ASSESSMENT REPORT

Nadine Street Residential Subdivision, Sanctuary Point DA 485-12-2002 MOD 1

TYPICAL 5m ROAD 01 CROSS SECTION
SCALE 1:50

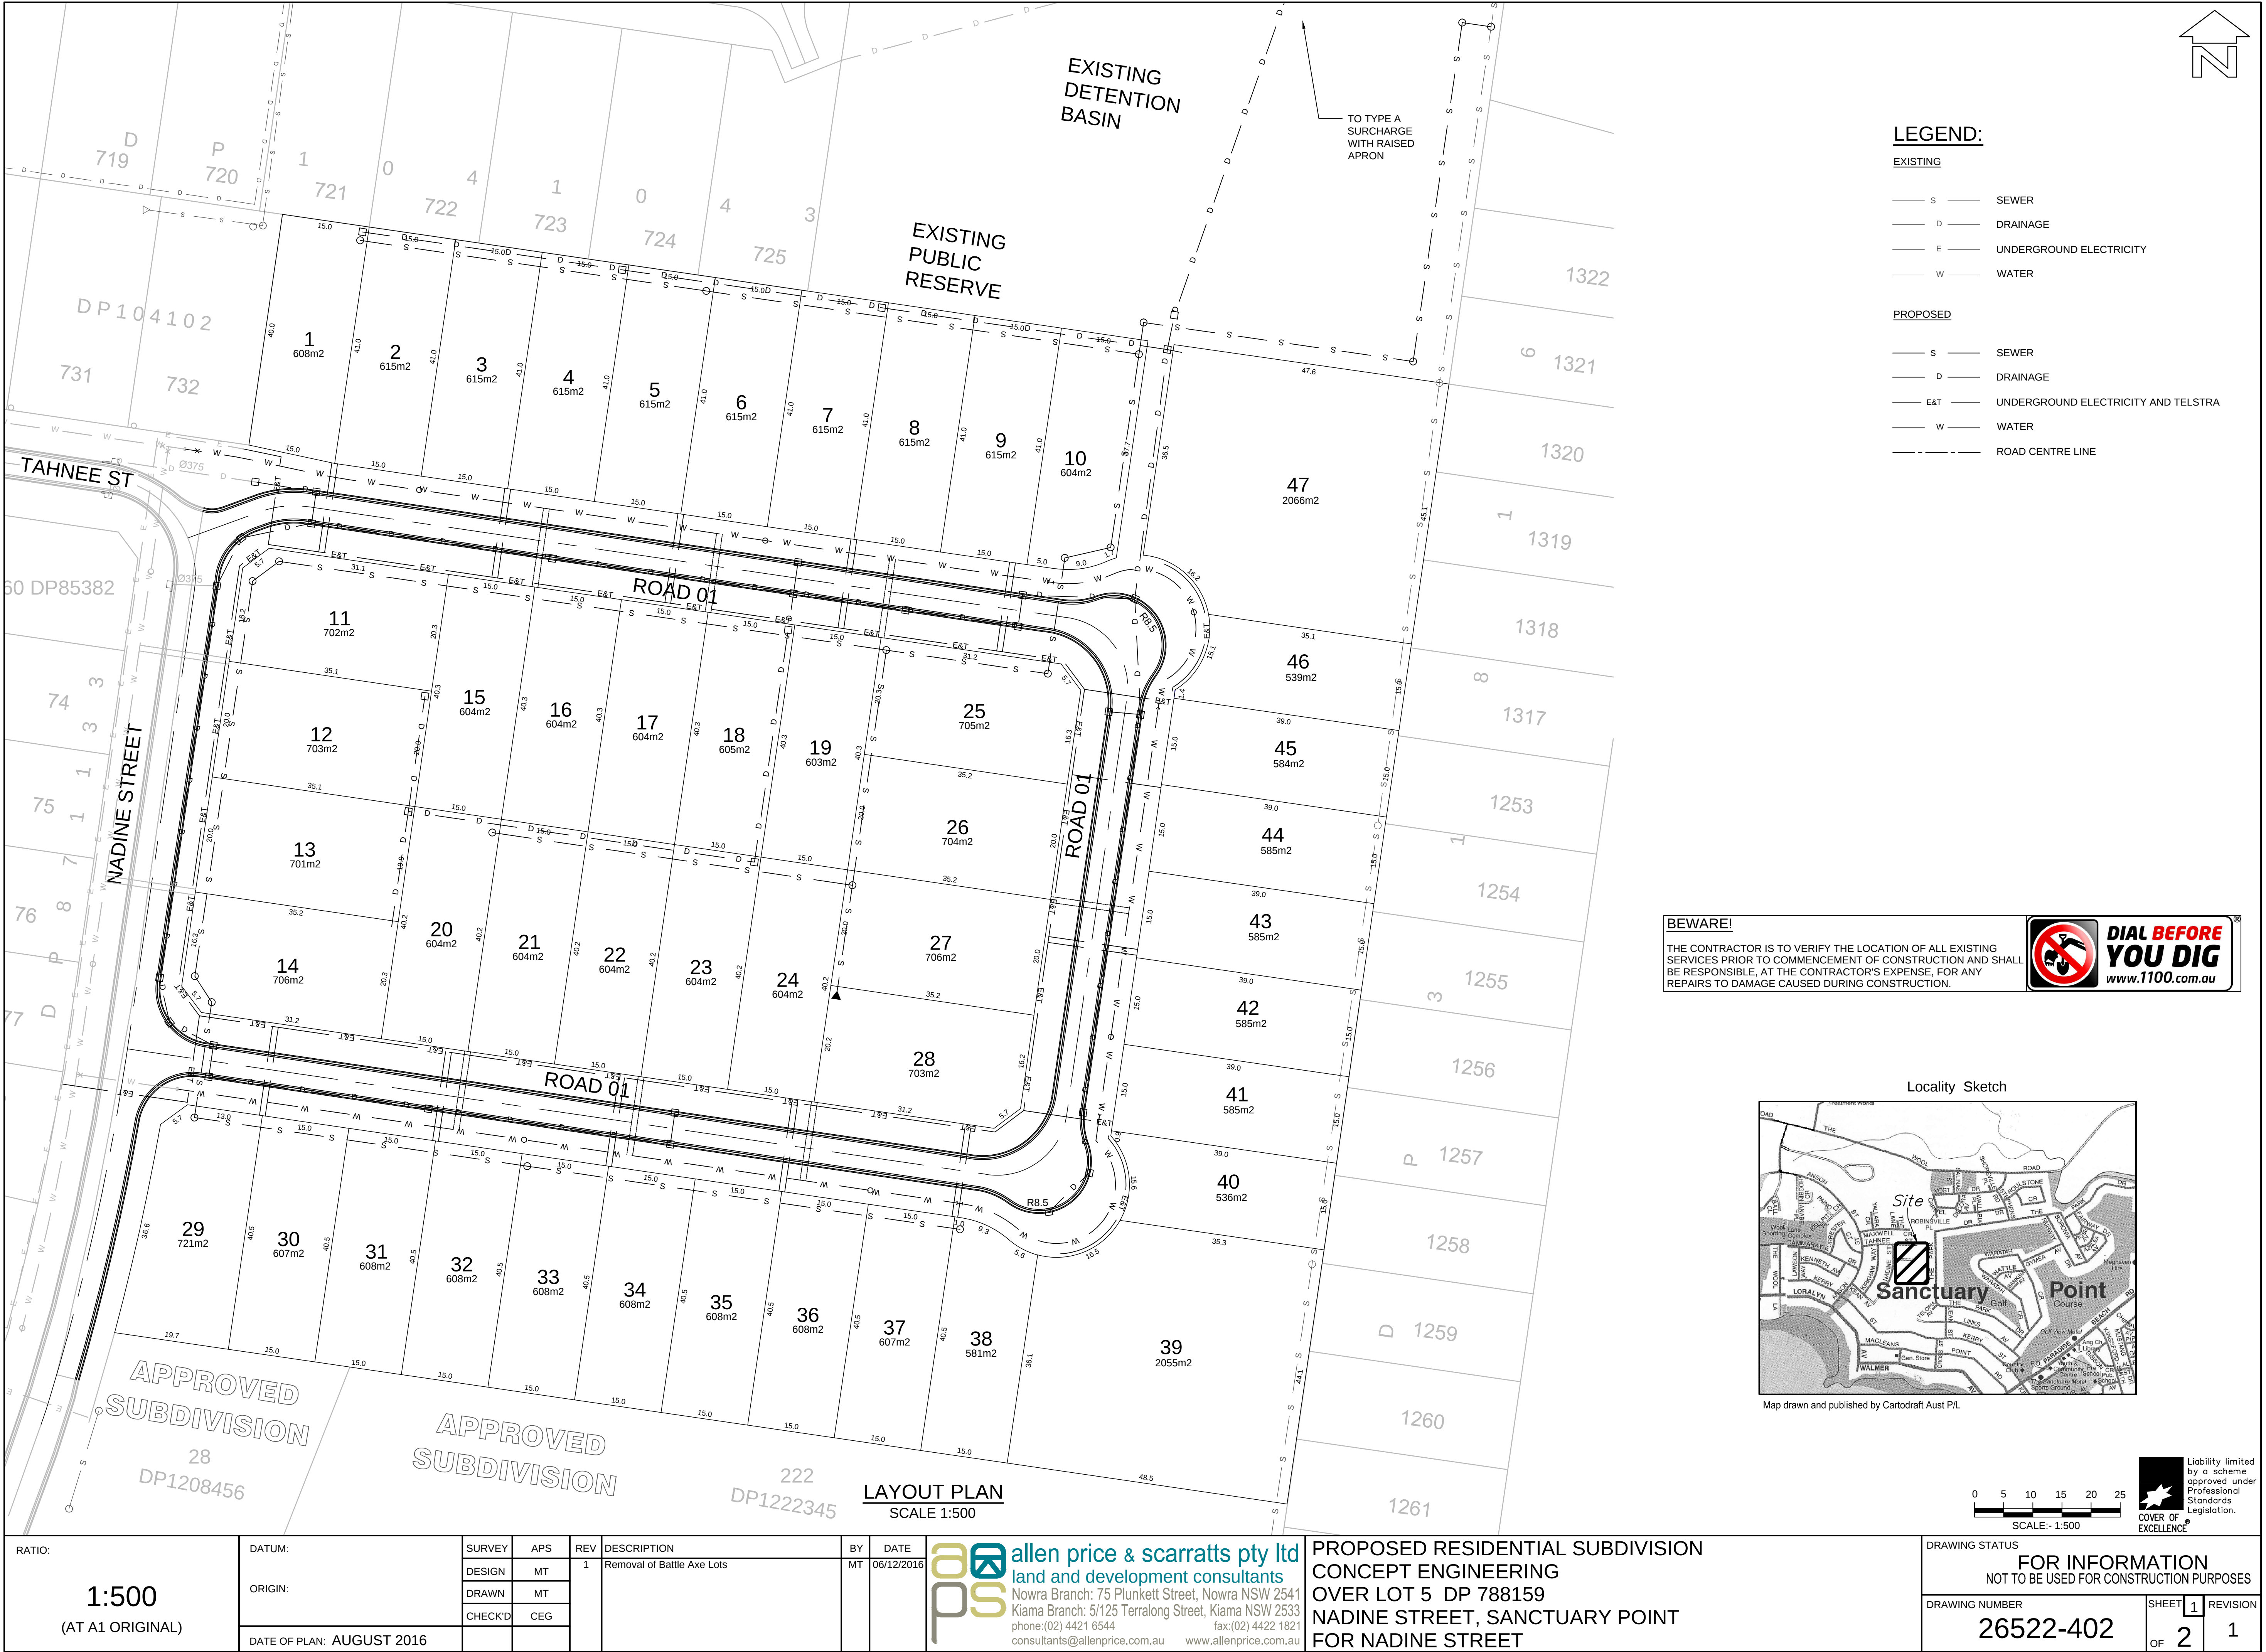
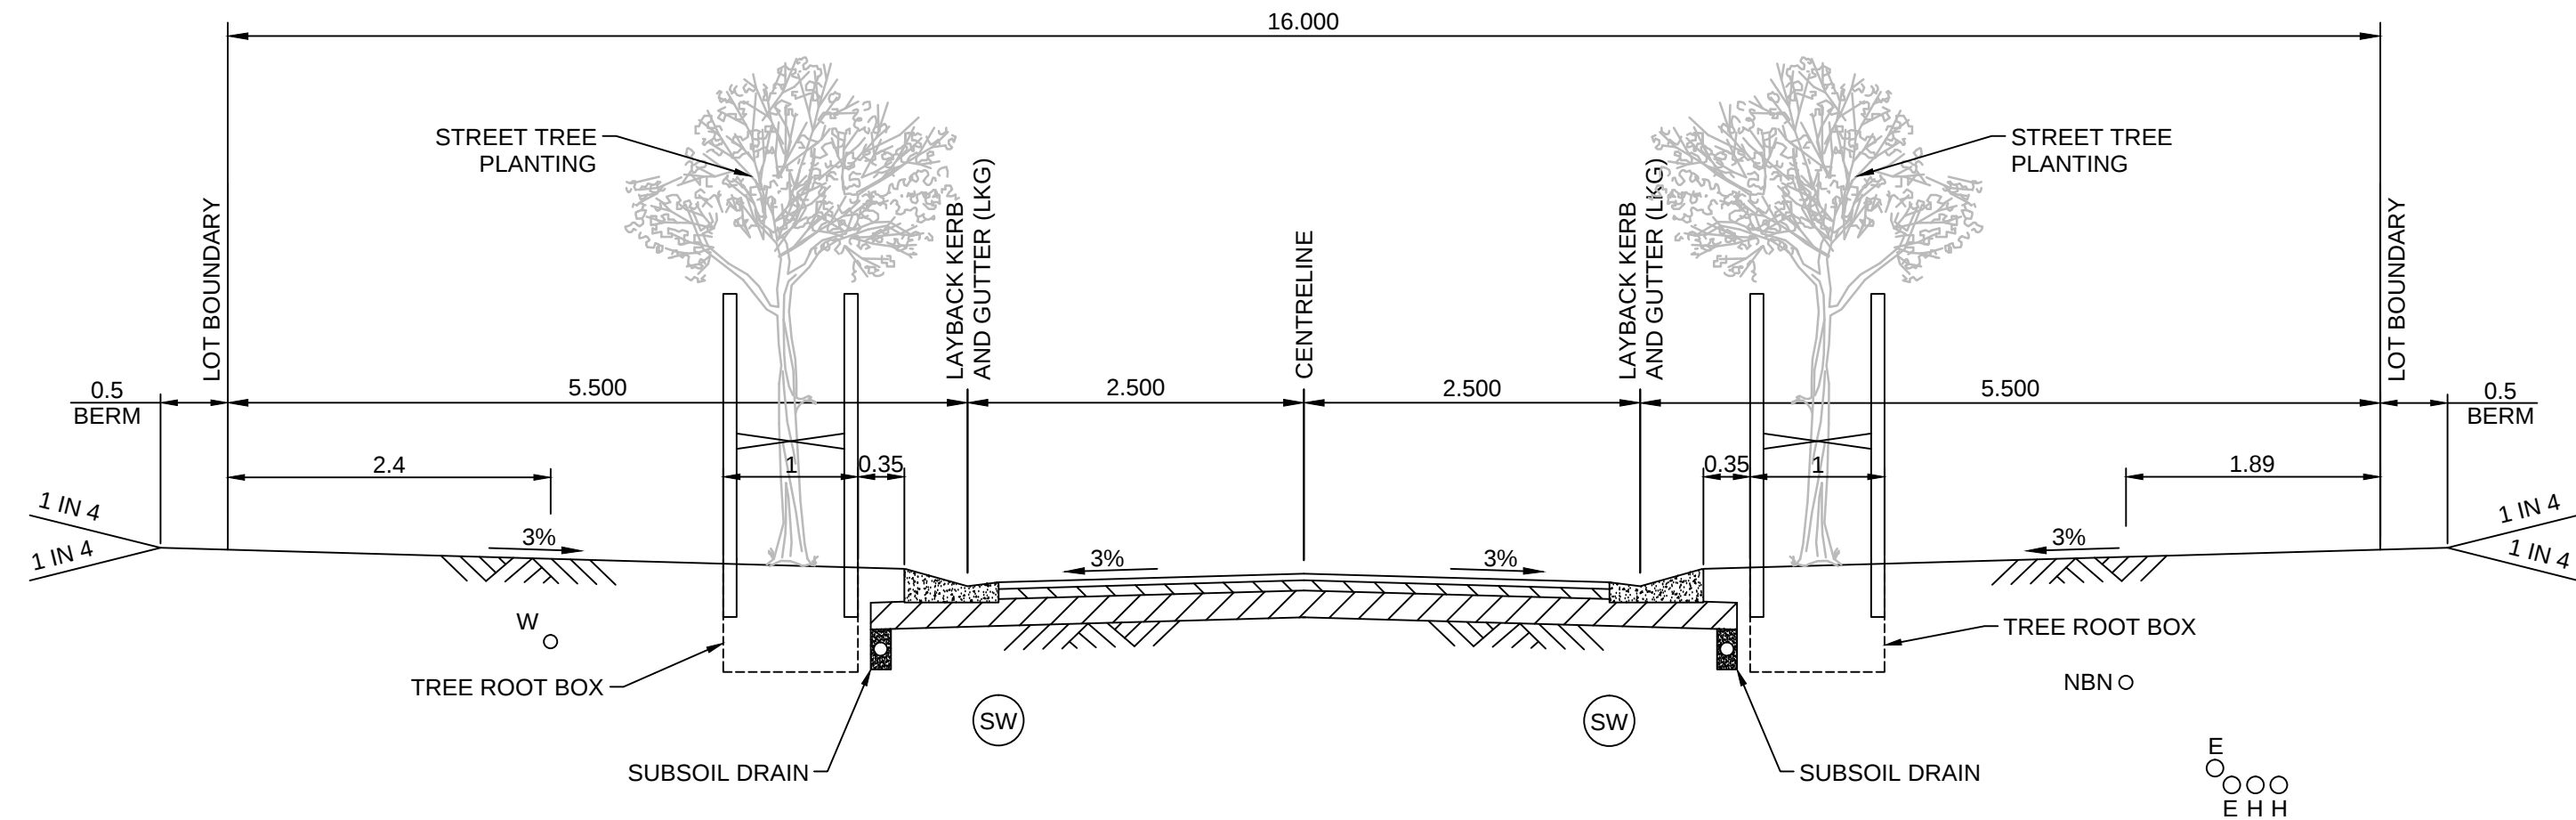
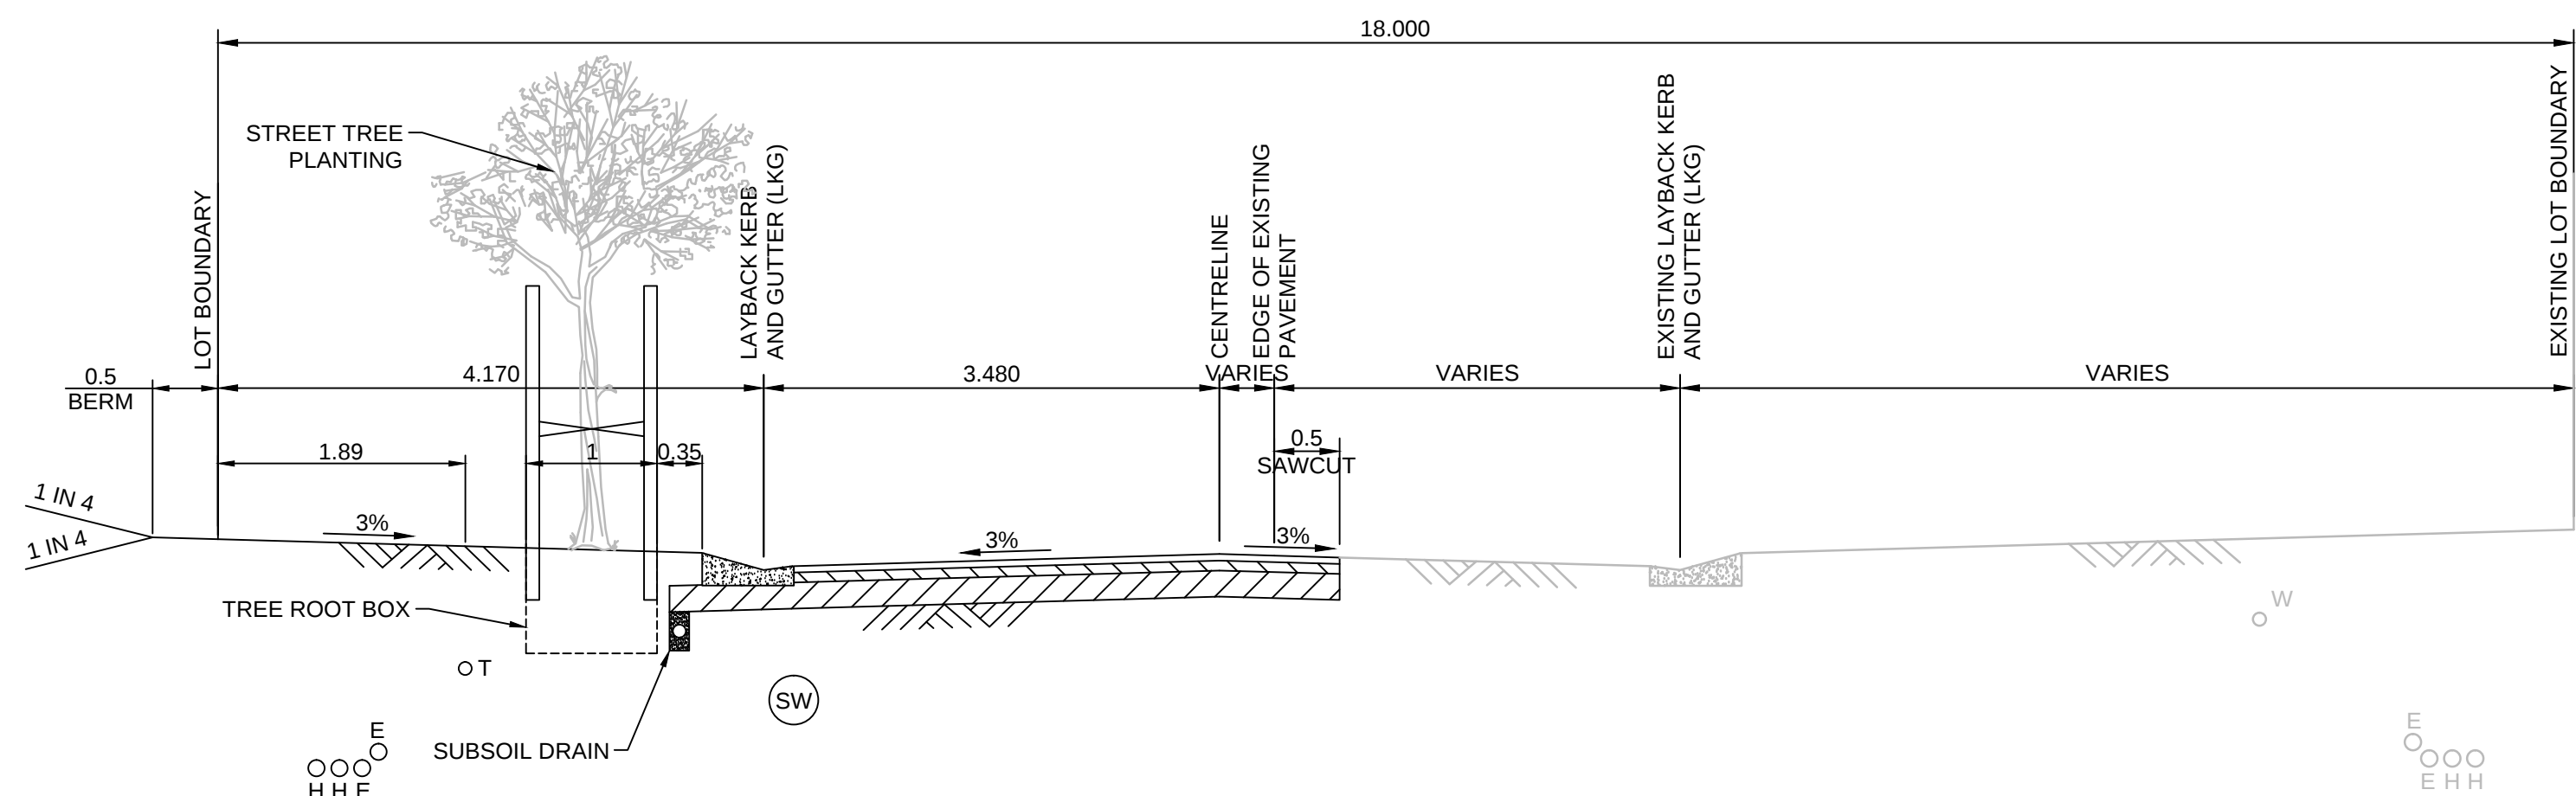
<i>Roadway widths</i>	- The proposal seeks to reduce the width of the road reserve by 2 m (from 18 m to 16 m). - Concern was raised in public submissions about the potential traffic and safety impacts of reducing the width of the road reserve. Council raised concern that the reduced width would constrain the opportunity for on-street parking and landscaping. - The Proponent states: - the reduced roadway reserve width complies with the minimum width recommended by SDCP 2014 for an 'Access Street'; - the road carriageway width is unchanged from the original DA approval; - car parking is not permitted on road verges and therefore a change to the verge width would not impact on car parking; and - sufficient space is provided within each lot for on-site car parking. - SDCP 2014 requires a minimum road reserve width of 16 m for Access Streets and 18 m for Local Streets. SDCP 2014 defines: Access Street as a street that is generally residential in nature, traffic is subservient and speed and volume are low (typically 15 – 50 dwellings); and Local Streets as collector streets that collect traffic from Access Streets and connect to major roads (typically 50 to 100 dwellings). - The Department notes the proposed road is a loop road not connected to a major road and would contain 47 dwellings when developed. The Department considers the loop road to be an Access Street in accordance with the SDCP 2014 definition and, therefore, a minimum 16 m road reserve width is applicable. - The Department is satisfied the width of the proposed road reserve	The Department has recommended Condition B2 be amended to reflect the amended road reserve width, lot types and numbering.
